CITY OF PORTLAND, MAINE
HISTORIC PRESERVATION BOARD

Re: Exterior Alterations; 46 Avon Street

**PUBLIC HEARING
46 AVON STREET**

TO: Chair Romano and Members of the Historic Preservation Board
FROM: Rob Wiener, Preservation Compliance Coordinator
DATE: April 10, 2013
RE: April 17, 2013 Public Hearing

46 AVON
REAR VIEW

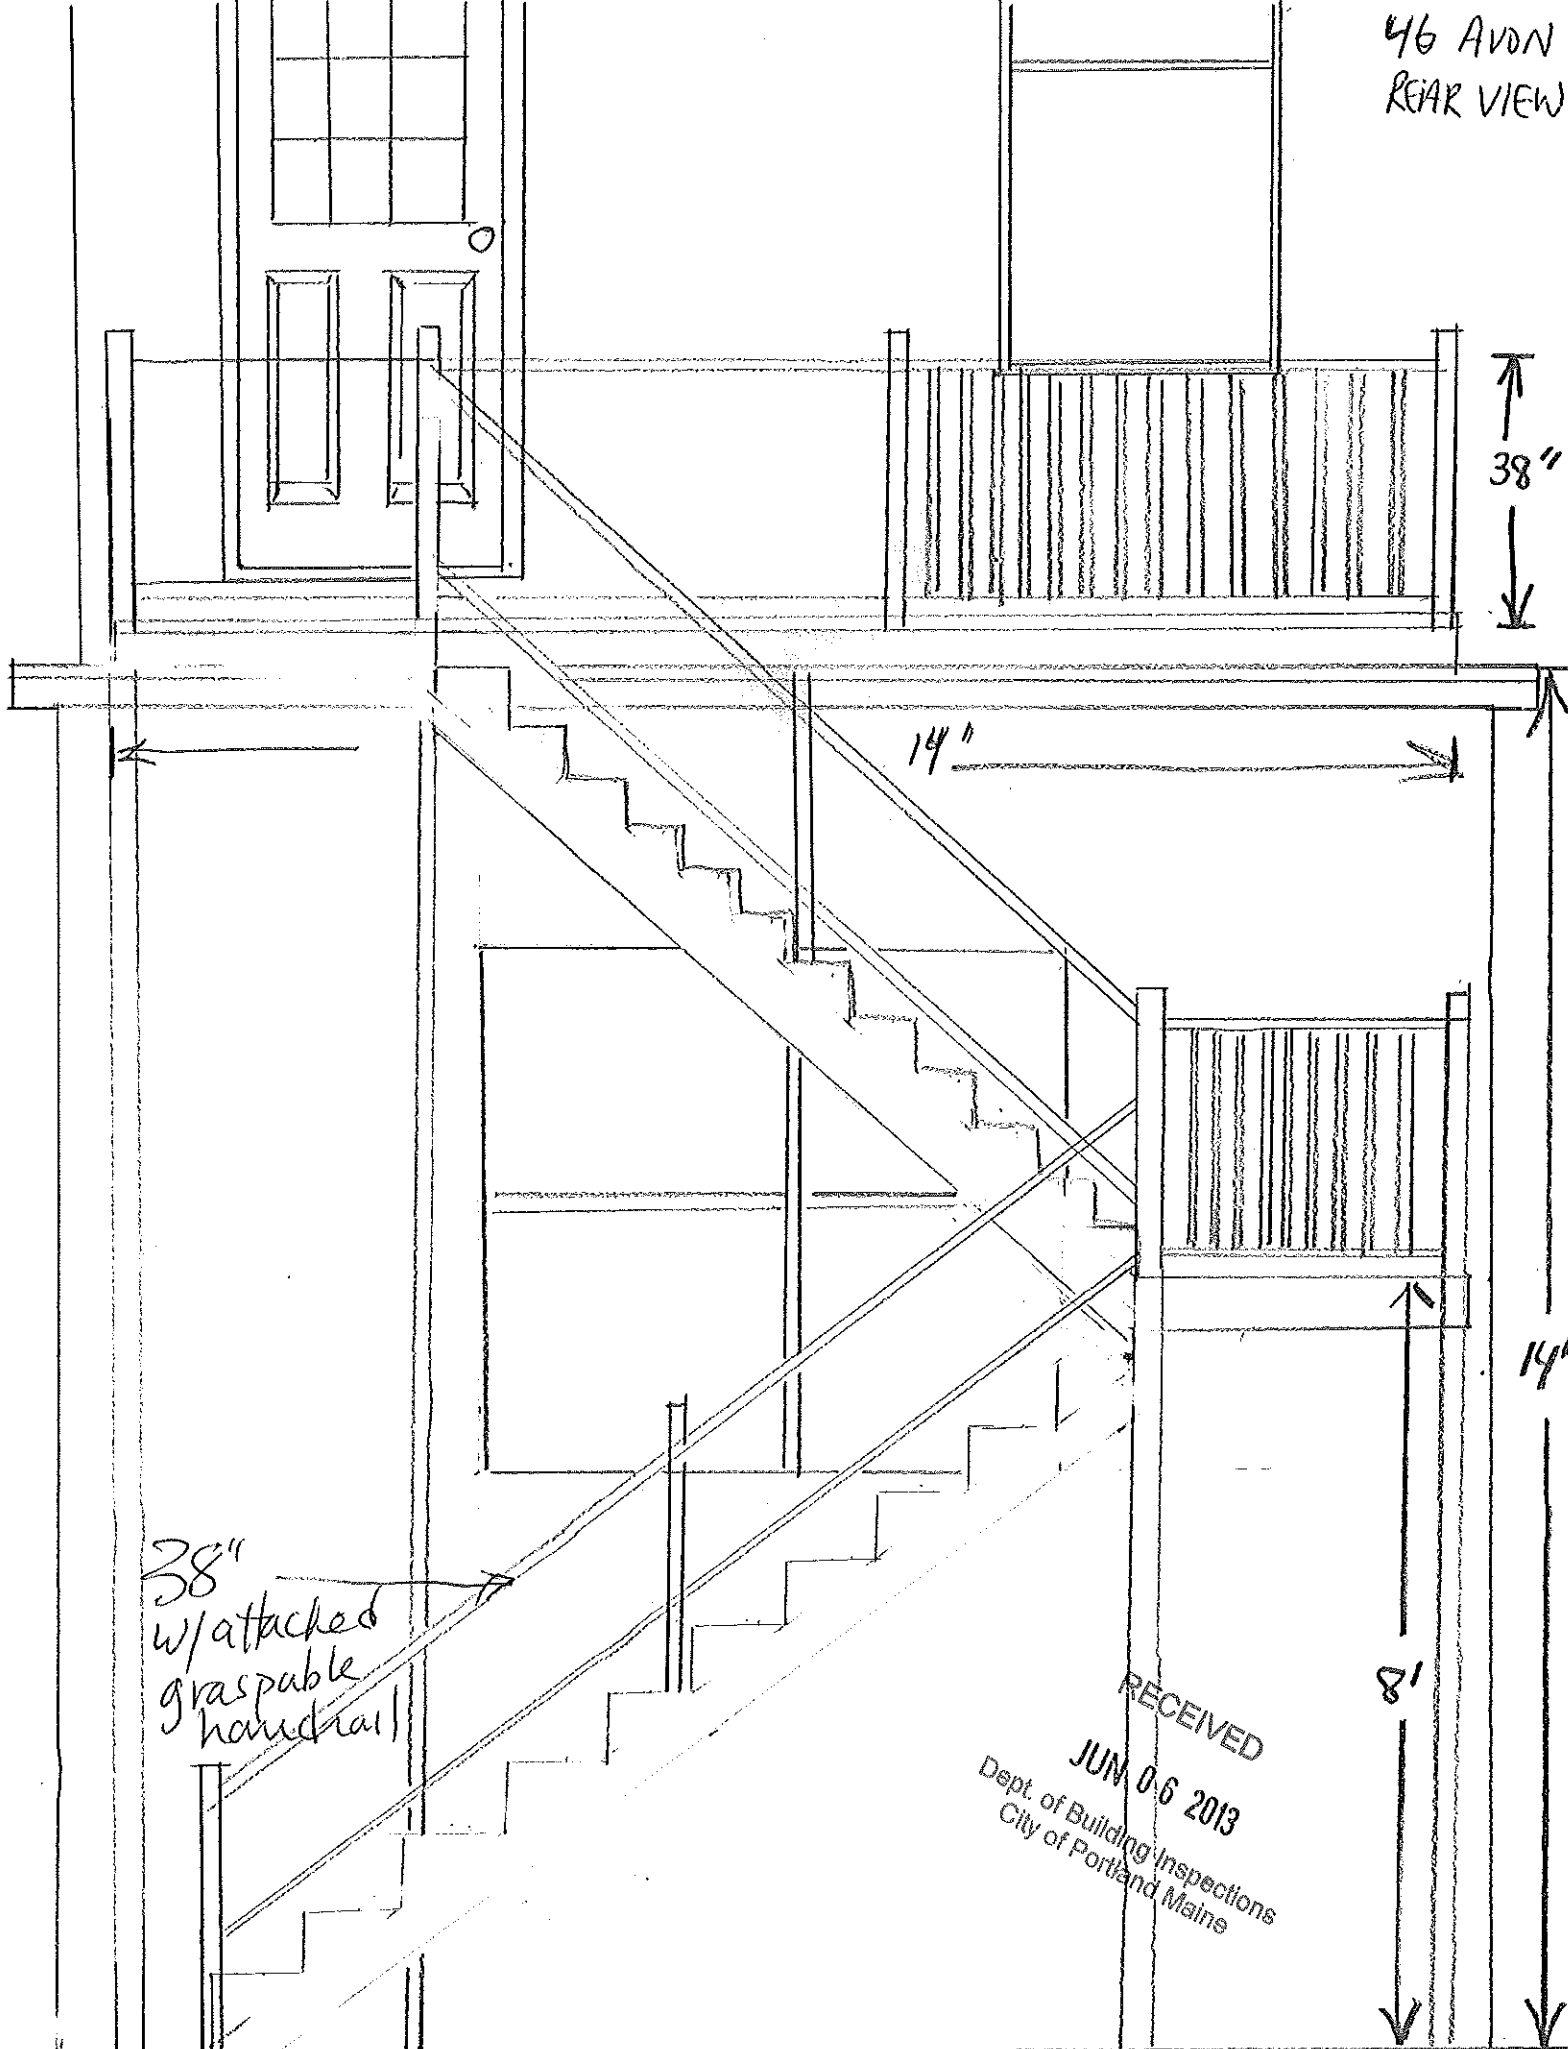
with the deck, which simplifies the railing and results in a less confused appearance. From the landing the stairs descend in the same direction as in the earlier submission (toward Deering), with a proposed rise of 7.75" and a run of 10.5". These do not meet current code standards of 7" and 11" but appear necessary to ensure that the stairs do not extend beyond either corner of the adjacent ell. The Director of Inspections expressed a willingness to consider favorably a waiver application for such dimensions if they are necessary to minimize visibility of these stairs. To minimize the total rise, the deck has been lowered as much as possible by creating a new, almost flat roof on the ell.

The applicant is proposing to install a pre-fabricated railing system of composite material. The rail height, as proposed, is 38". The balusters will be 1 ½" square balusters spaced 3 ½" apart. The applicant is proposed pressure-treated treads with solid white painted risers. No skirting/screening is proposed at the base of the stairs.

The simplification of the landing and railing at the top of the stairs will result in less visual clutter and greater ease of installation. The Board may want to discuss the most appropriate material and style for the railing system, as well as whether to seek a guardrail height lower than the code-mandated 42 inches. Post and railing details will not be viewed at close range but should be expected to appear generally appropriate to the period of the house. The Board will want to confirm whether the railing specification included in the submission is the one proposed for installation. (The meeting notes suggest that a substitute might be installed.)

1. Applicant to inform Historic Preservation staff when painting is completed, including pressure-treated stair carriage, risers, and landing framing.
2. Railing system of white vinyl is to include post sleeves and "New England" post caps.
3. Pressure-treated posts supporting landings and stairs shall be wrapped with white painted trim stock.
4. Historic Preservation Board recommends the granting of historic waivers to lower guardrail heights if possible.

46 AVENUE
SIDE VIEW

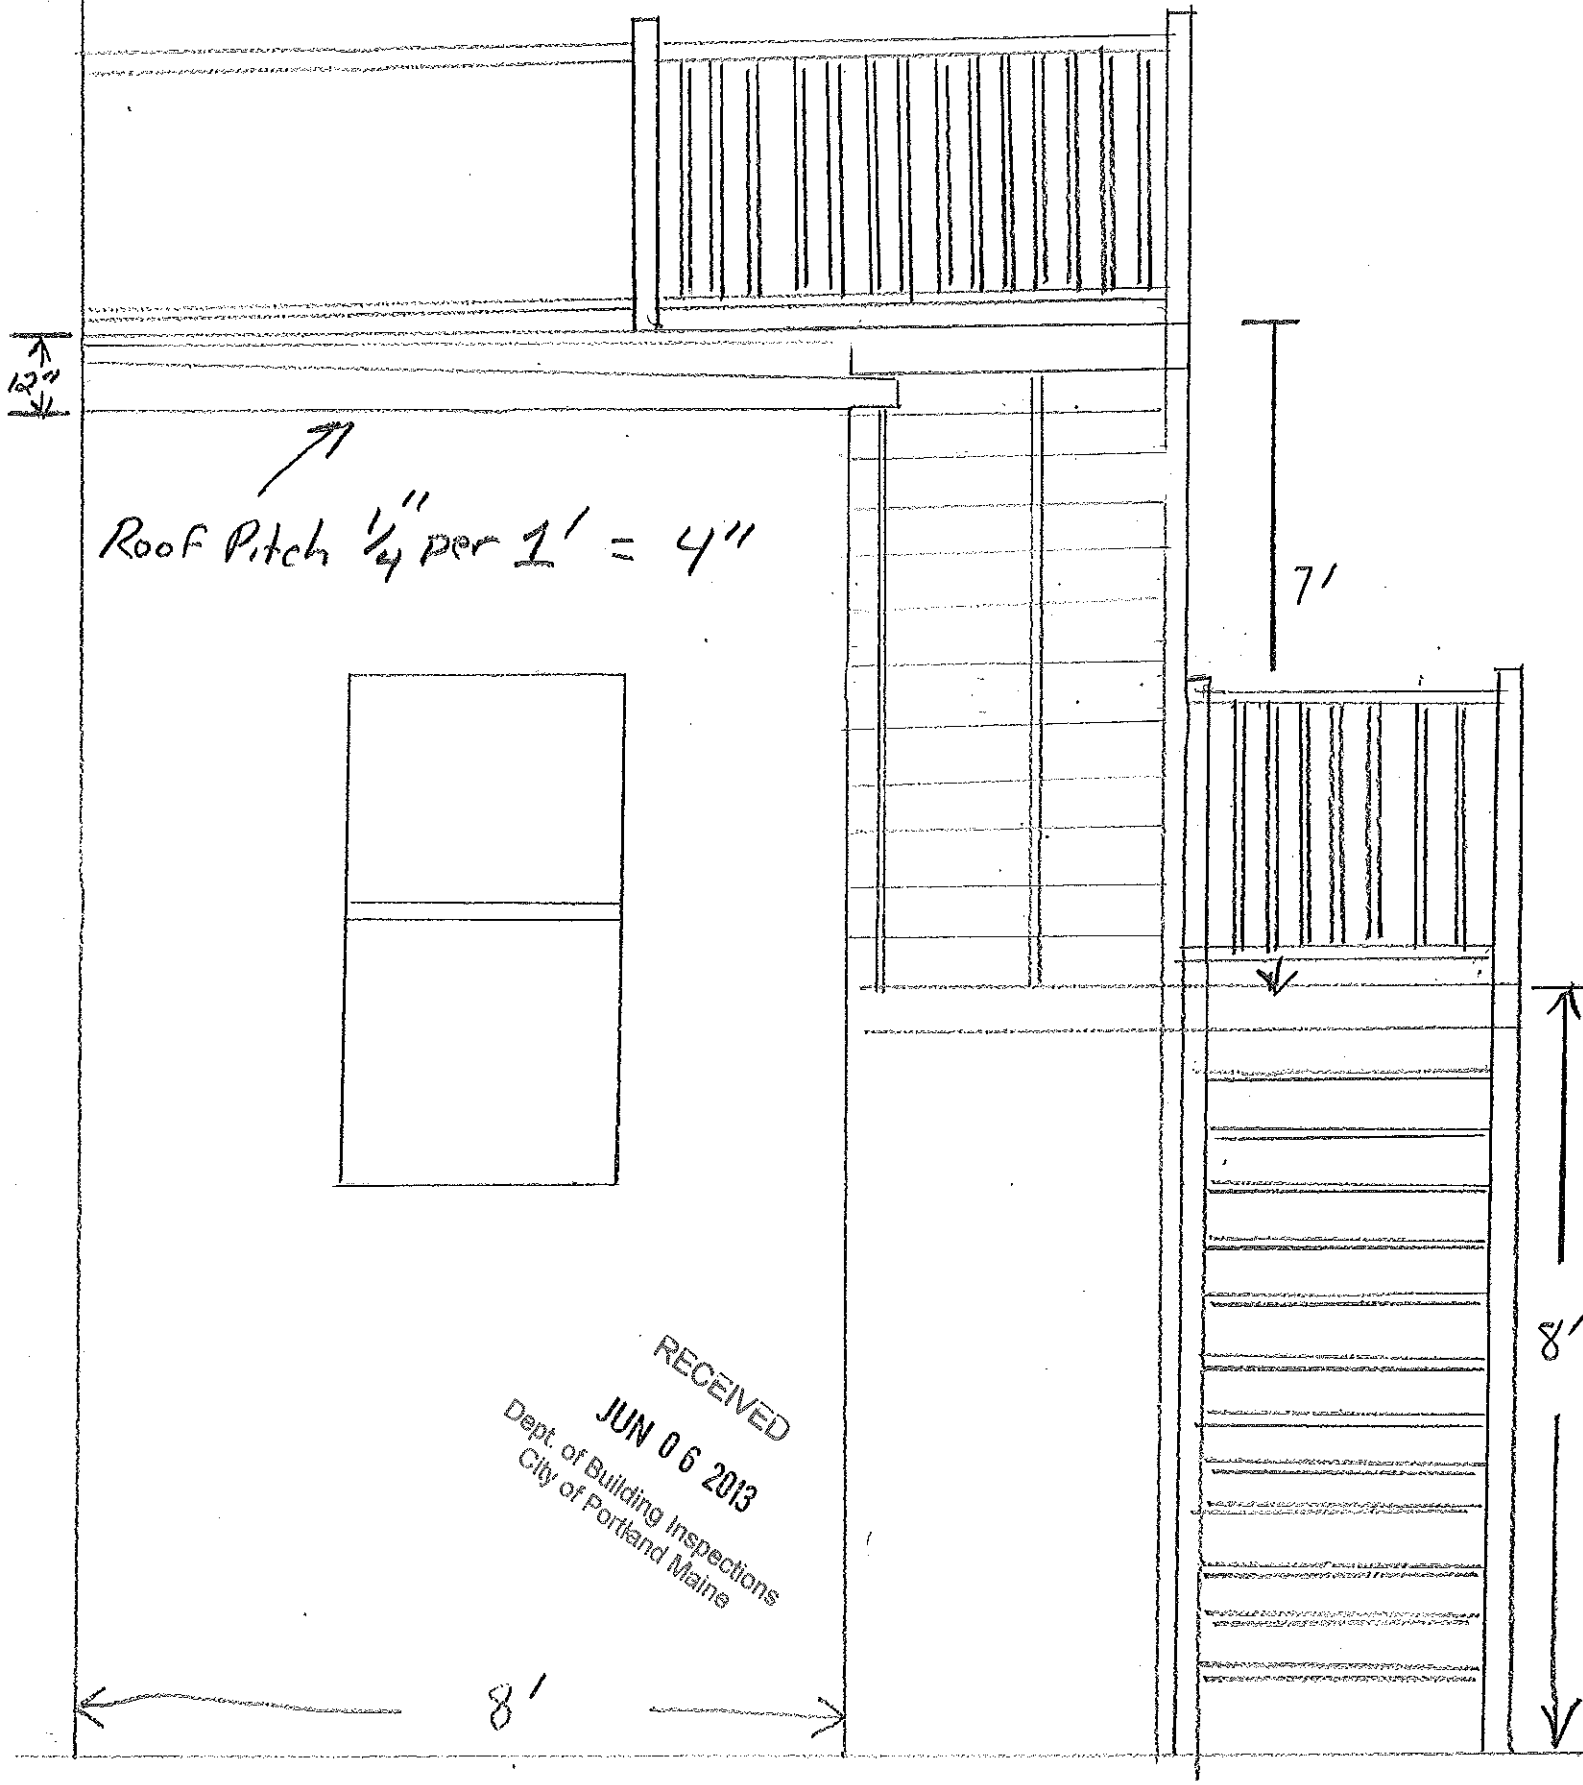
At the March 20 meeting there was insufficient time to discuss whether the height of the posts supporting the stair landings call for wrapping of the posts and/or lattice or some other means of enclosing the ends under stairs and landings. Such screening is neither necessary nor desirable on the west side, given the small back yard hemmed in by fencing and other buildings, and the need for some light for the bedroom window on the first floor.
